From: Amanda Scholes on behalf of Planning.Responses
Sent: 24 September 2018 08:59
To: Planning Scanning
Subject: FW: A/111/18/DOC
Attachments: RE: A/23/18/DOC - Broadlees, Dappers Lane, Angmering

Subject: URGENT - RE: A/23/18/DOC - Broadlees, Dappers Lane, Angmering

TREE PROTECTION (Plan 3A)

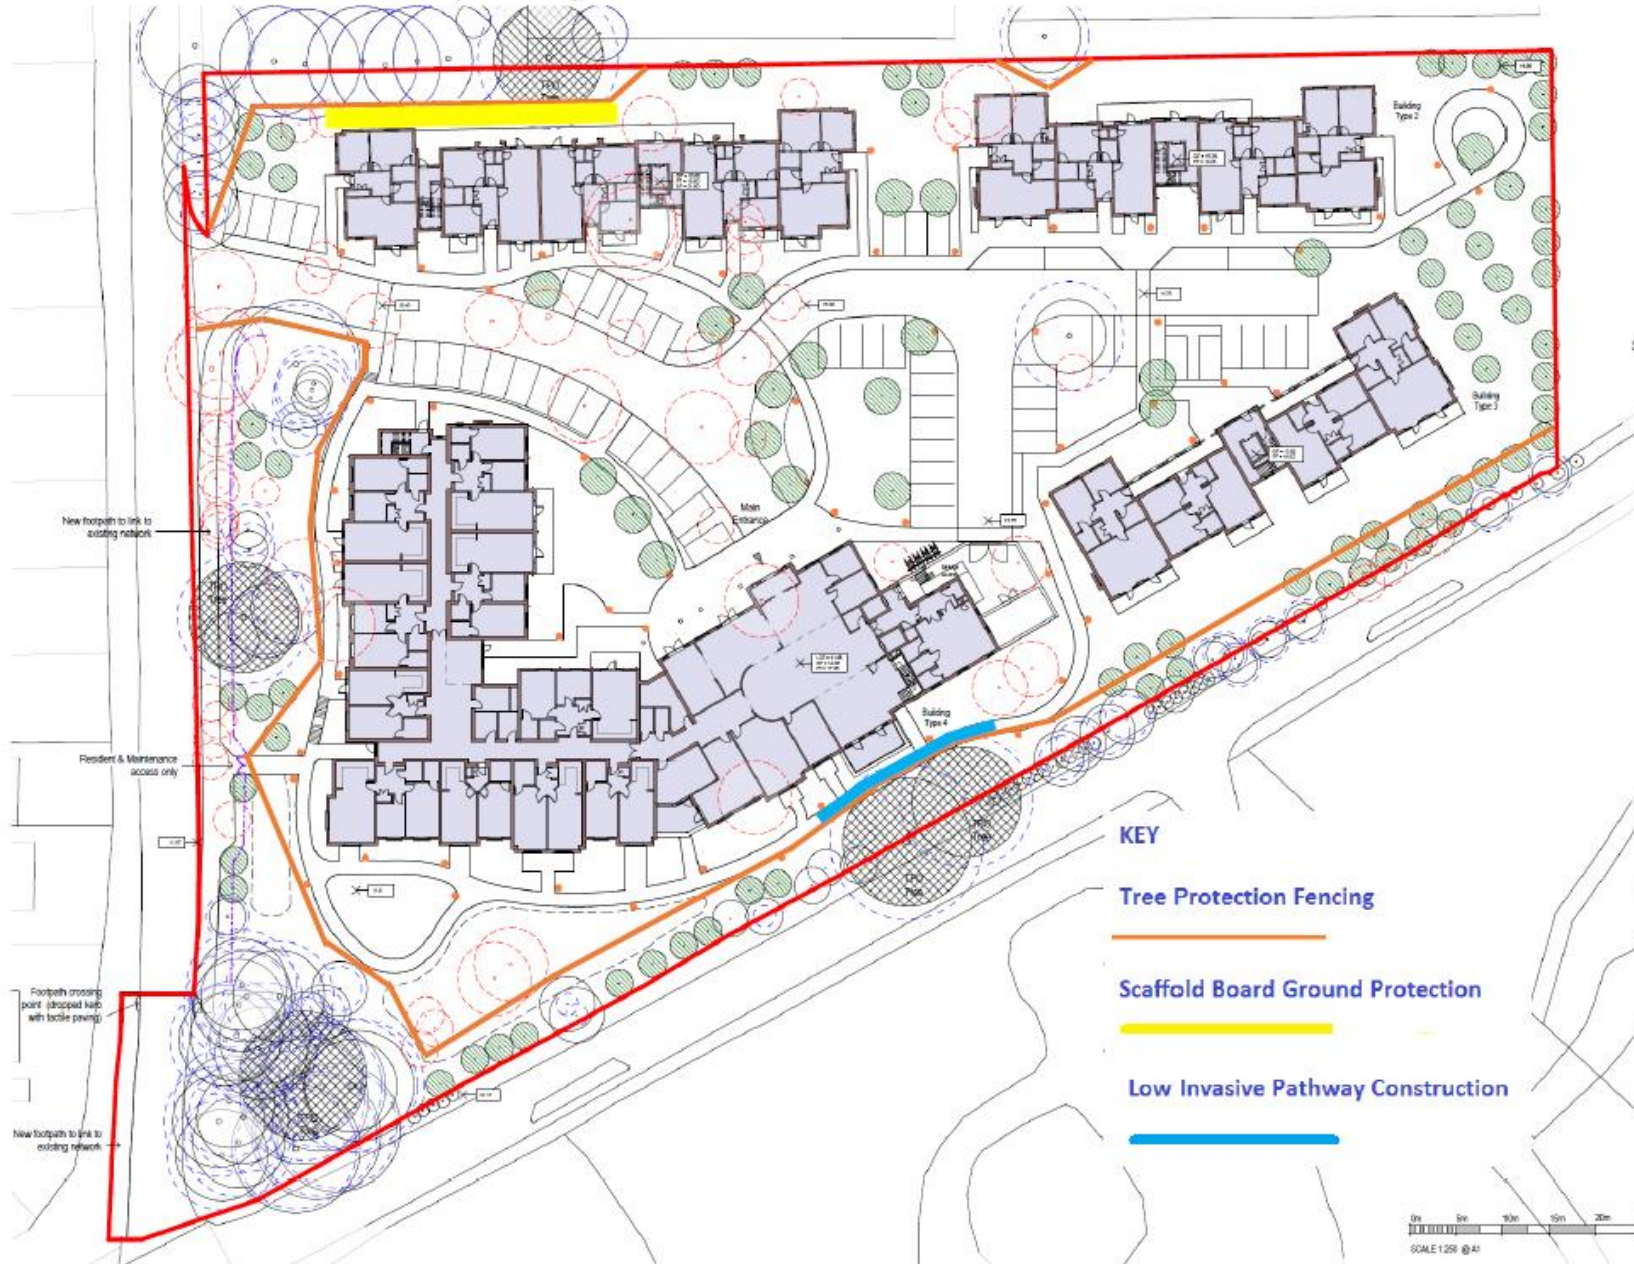
I note that the applicant has submitted a Tree Protection Plan Ref: Plan 3A – the measures set out on this plan are acceptable but will need to be implemented and then a Pre-Commencement Meeting can take place [at a mutually convenient time] between the applicants representative and the Arun DC Tree Officer to agree that the Protective Fencing complies with BS5837 recommendations and is 'Fit For Purpose' and that it has been erected exactly as shown on Plan 3A".
